East Pye Solar EN0110014

BEPS RESPONSE ON DESIGN, THE WORKS PLAN AND THE DRAFT DEVELOPMENT CONSENT ORDER

Cross-reference of APP/7.17, APP/7.18, APP/2.3 Revision B and Draft DCO Revision 2

Submitted by BEPS (Block East Pye Solar [REDACTED])

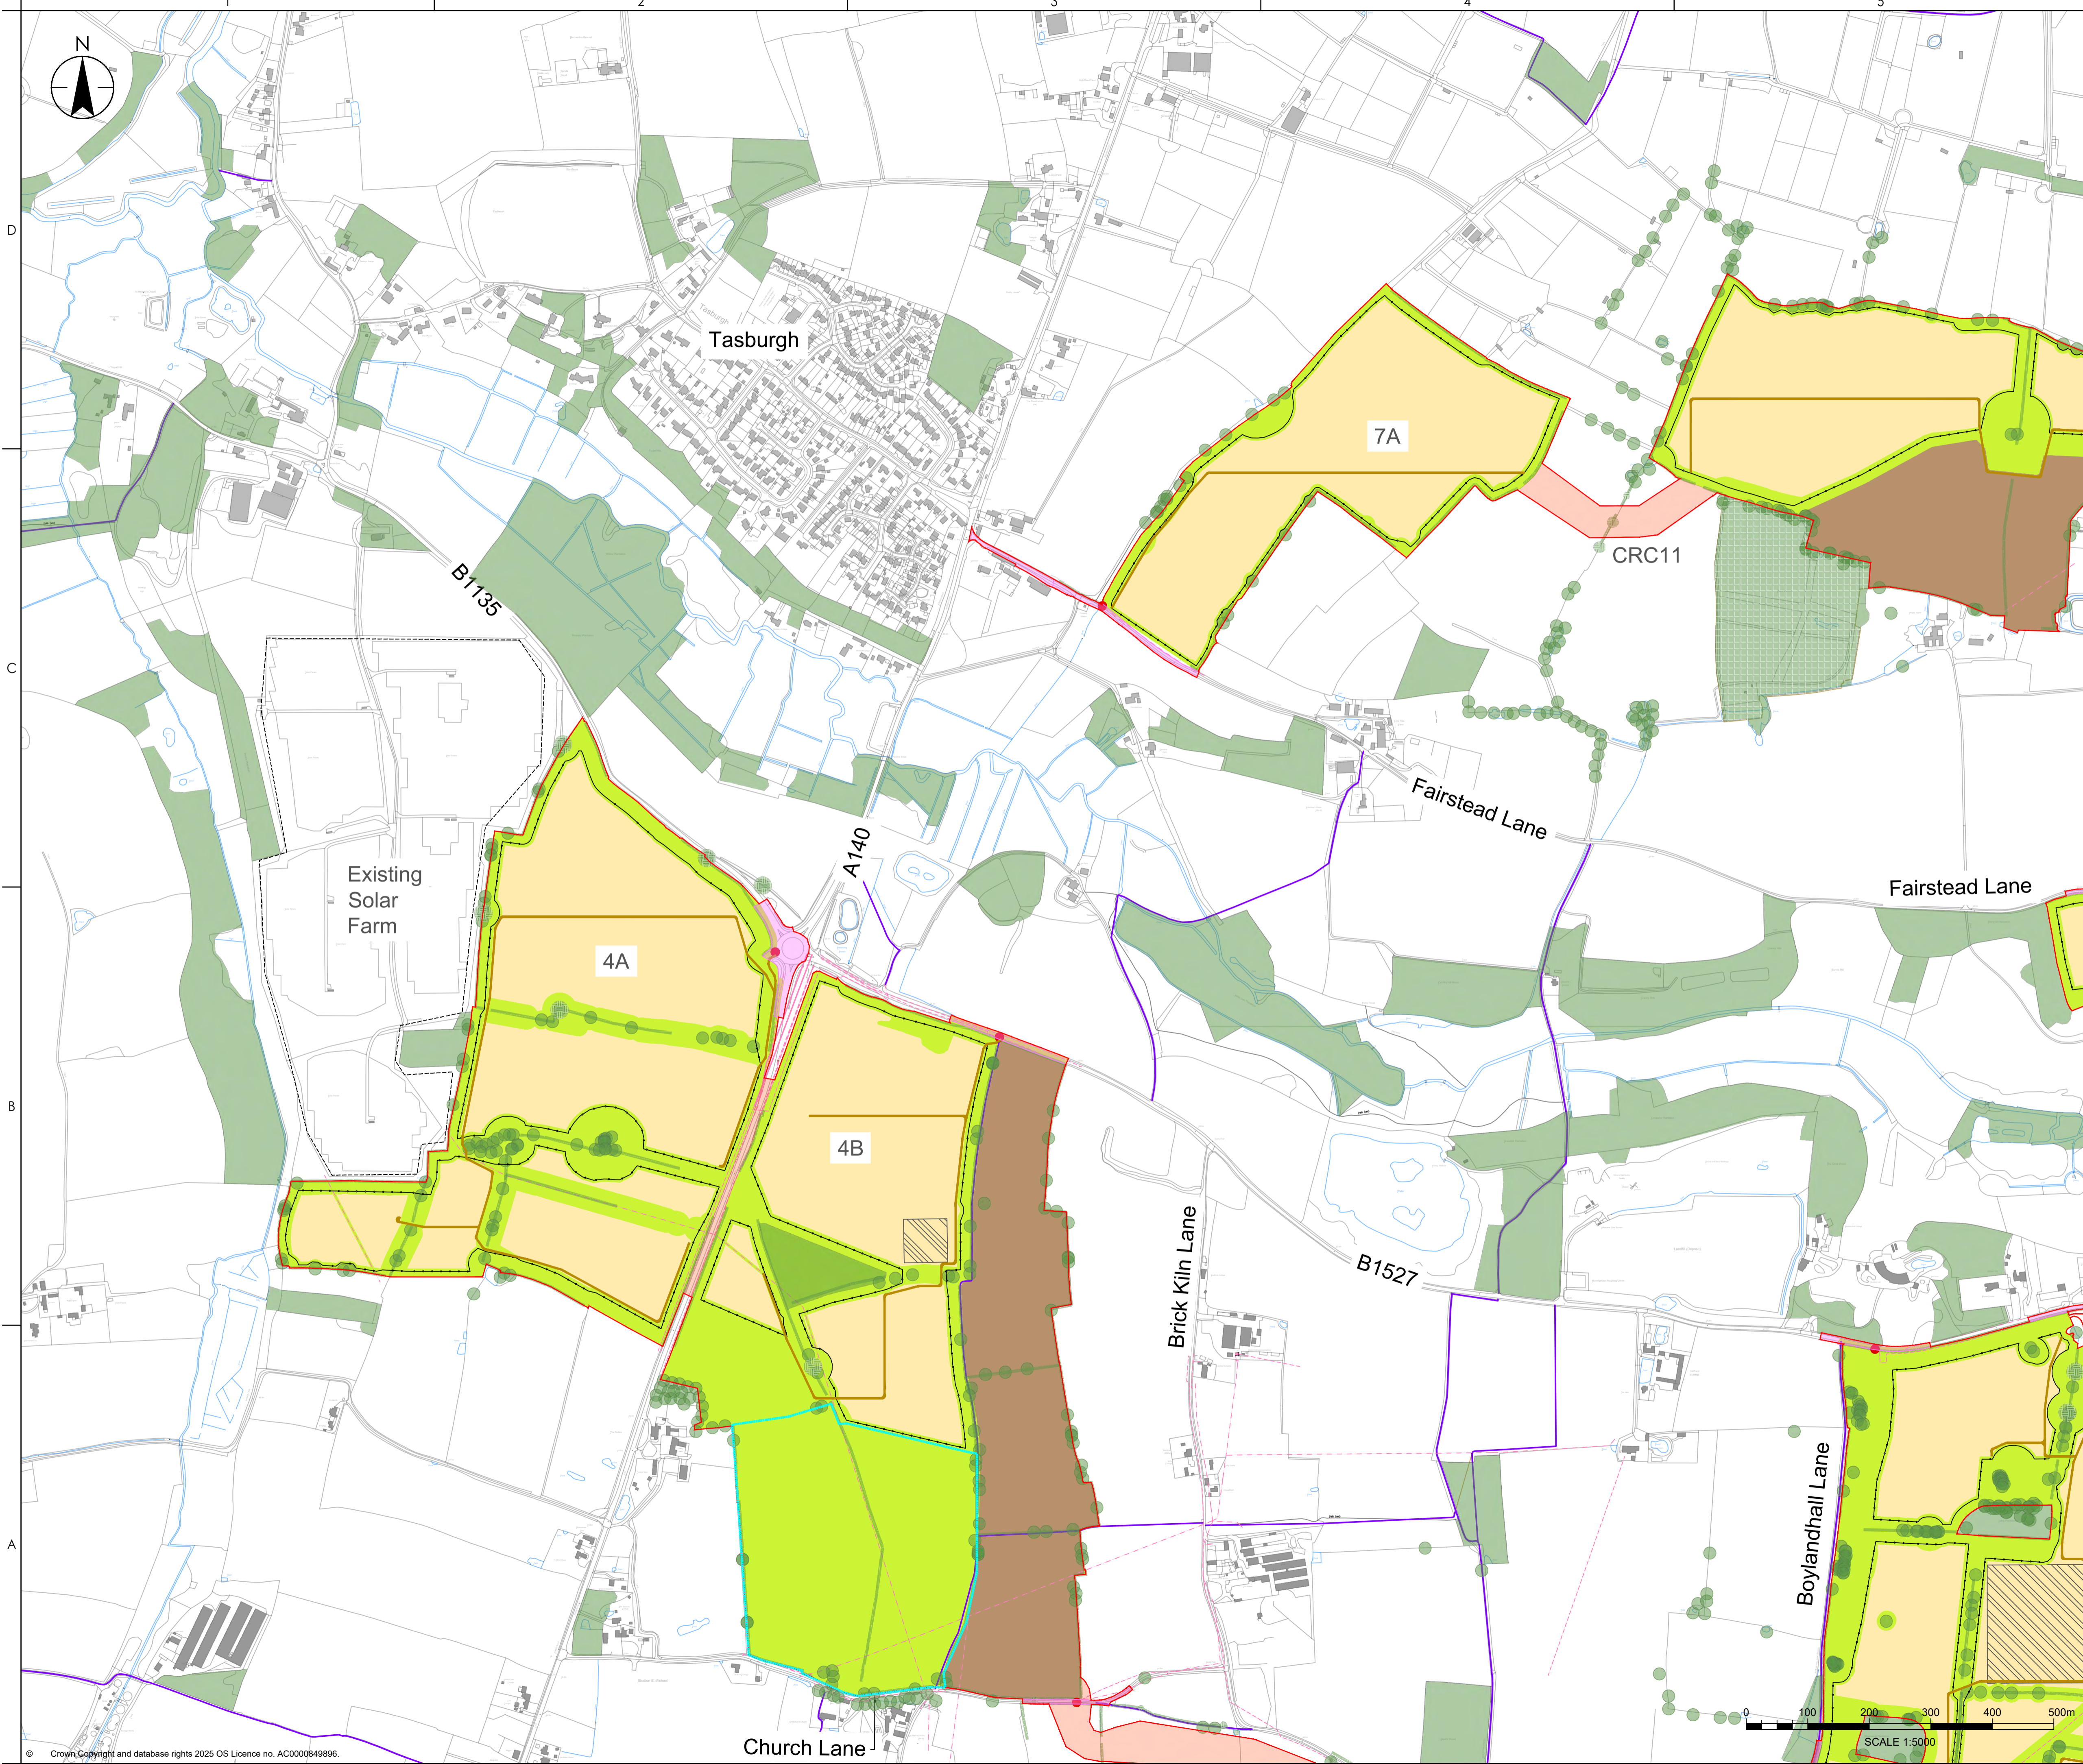
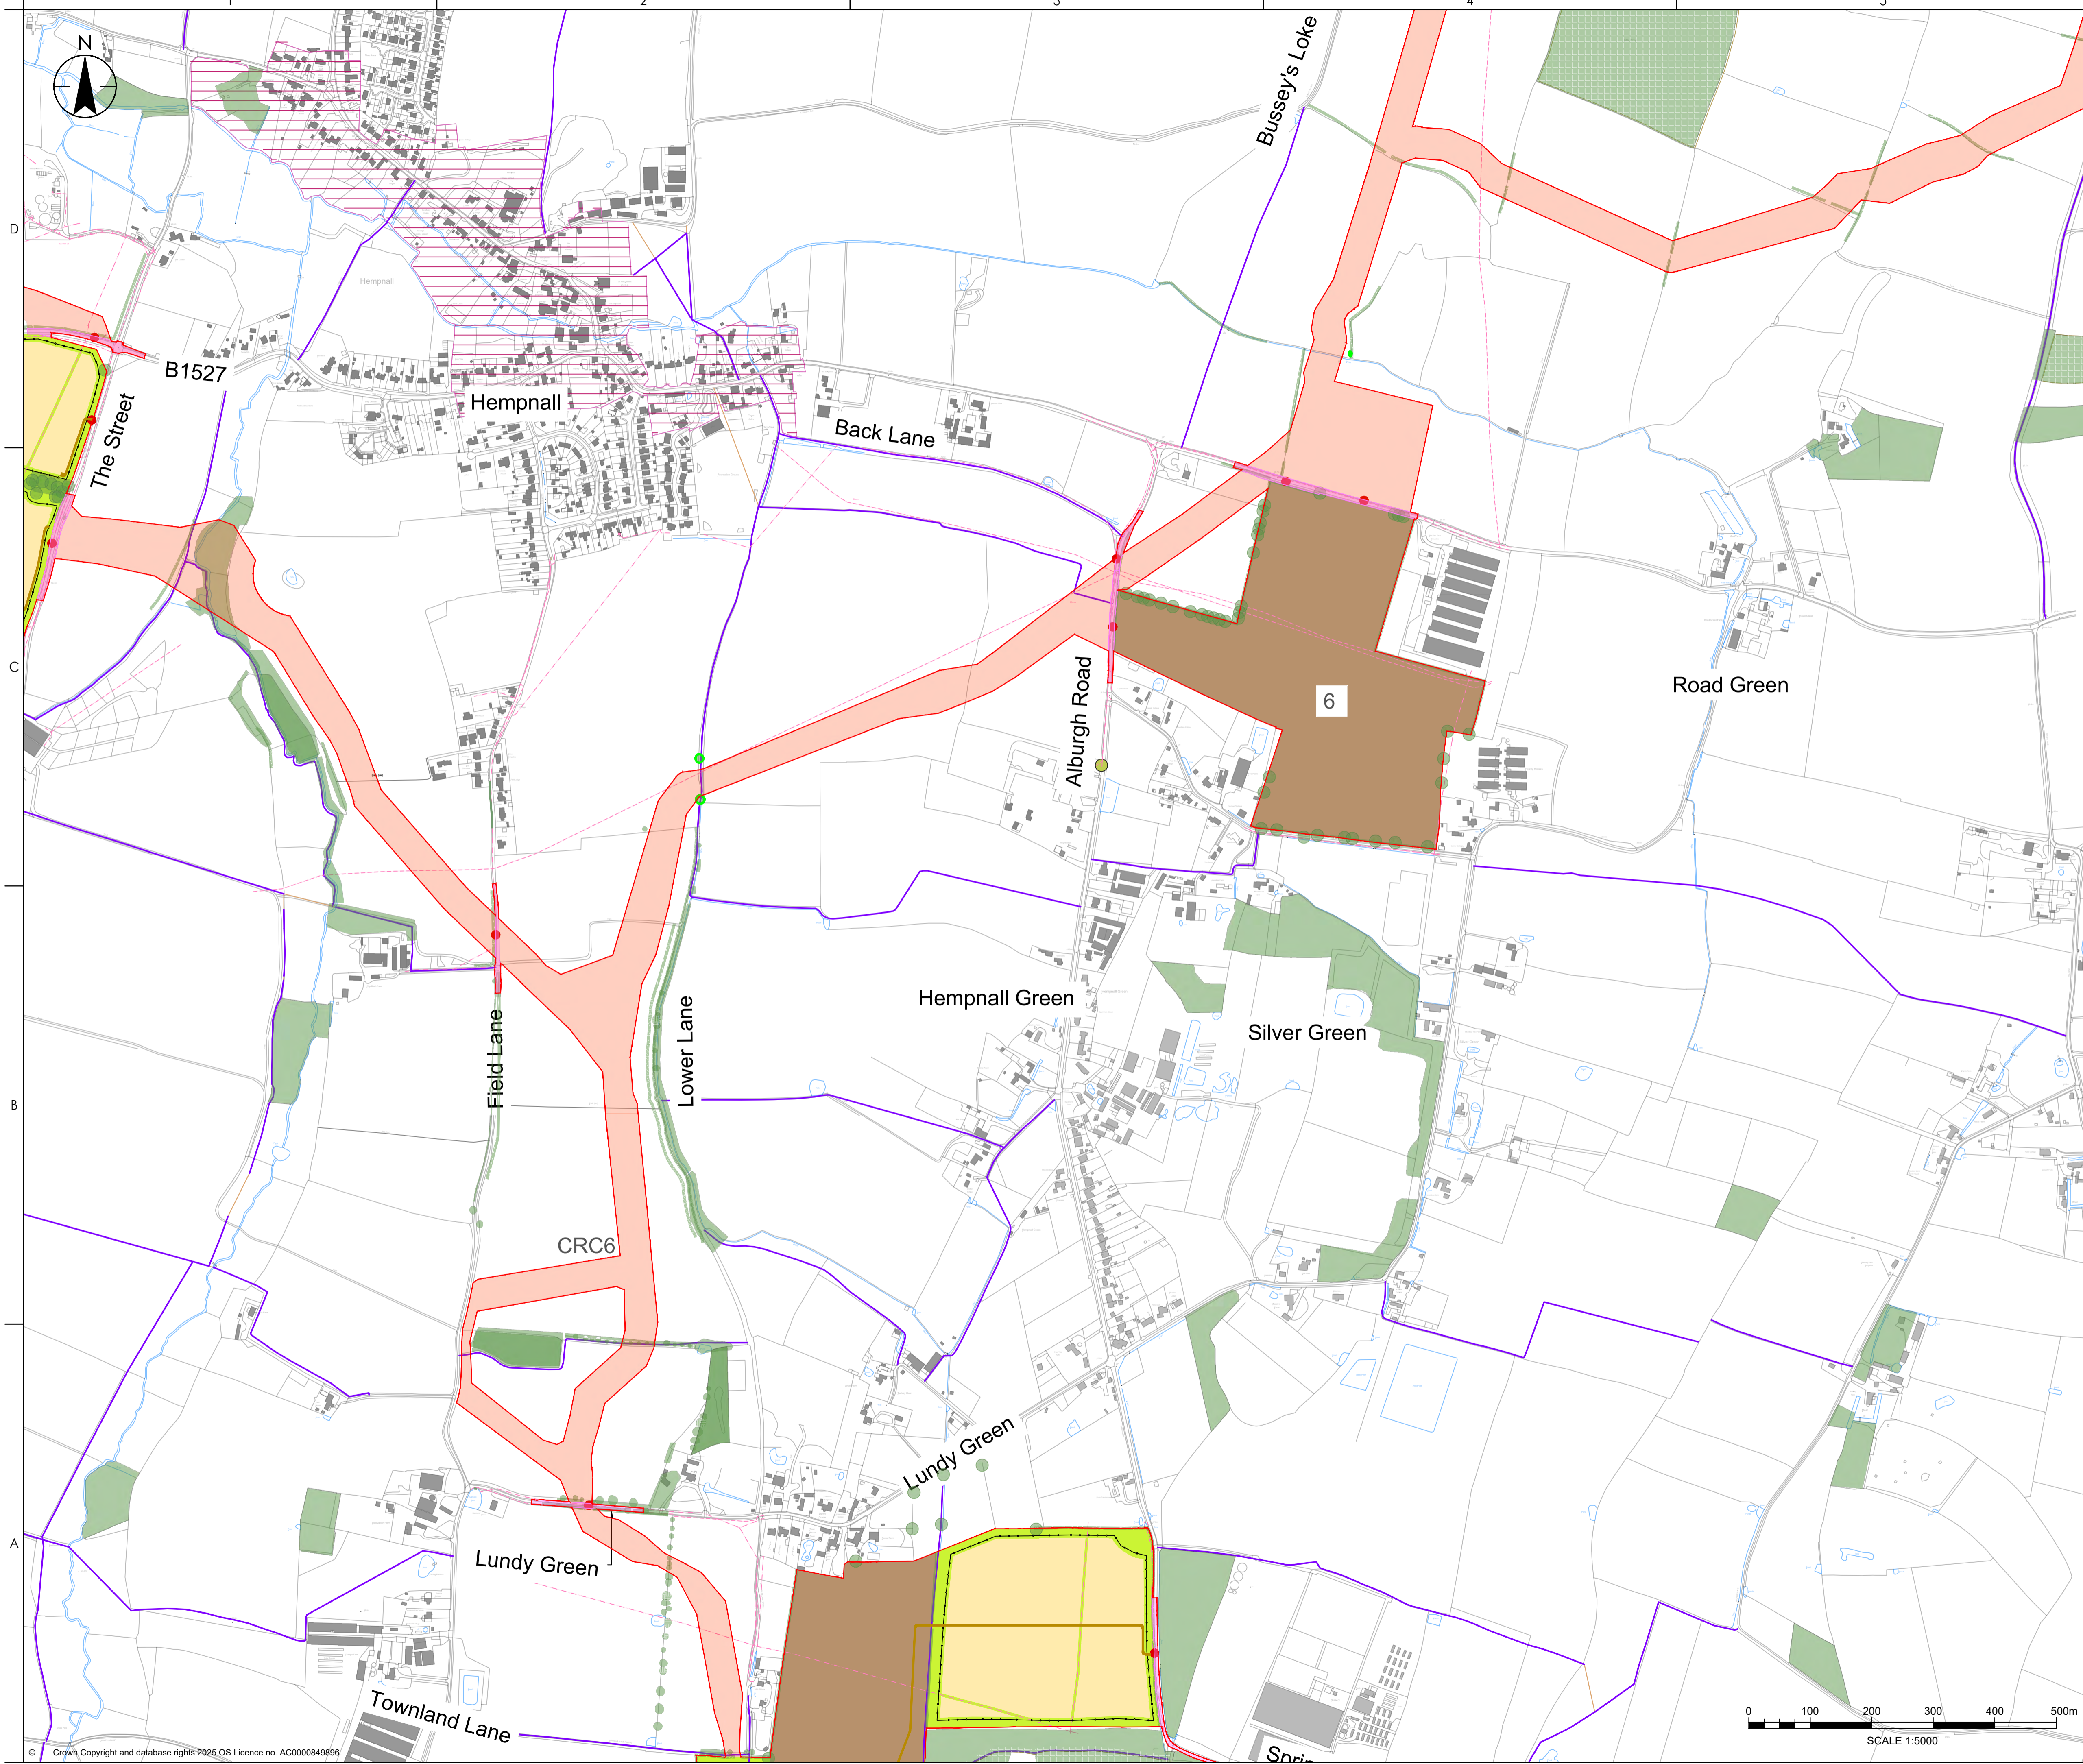
The DAD uses the Indicative Masterplan to demonstrate design evolution and quality, but it is not the consented layout. Article 3 requires numbered works to be situated within the corresponding numbered areas on the Works Plan. The Works Plan therefore defines broad envelopes, often with several Work layers over the same land. The correct test is whether any detailed layout lawfully available inside those envelopes remains within the reasonable worst case assessed by the ES.

BEPS asks that every design benefit shown only illustratively be accompanied by a simple schedule stating whether it is legally secured, by what provision and with what permissible tolerance.

The DAD presents setbacks at Sites 4B, 5 and 7 and increased mitigation at Site 3 as successful design evolution. The ExA should distinguish between screening or offset and genuine avoidance. Where the heritage or ecological case depends upon a setback, the setback should be a fixed minimum control rather than only an Indicative Masterplan feature.
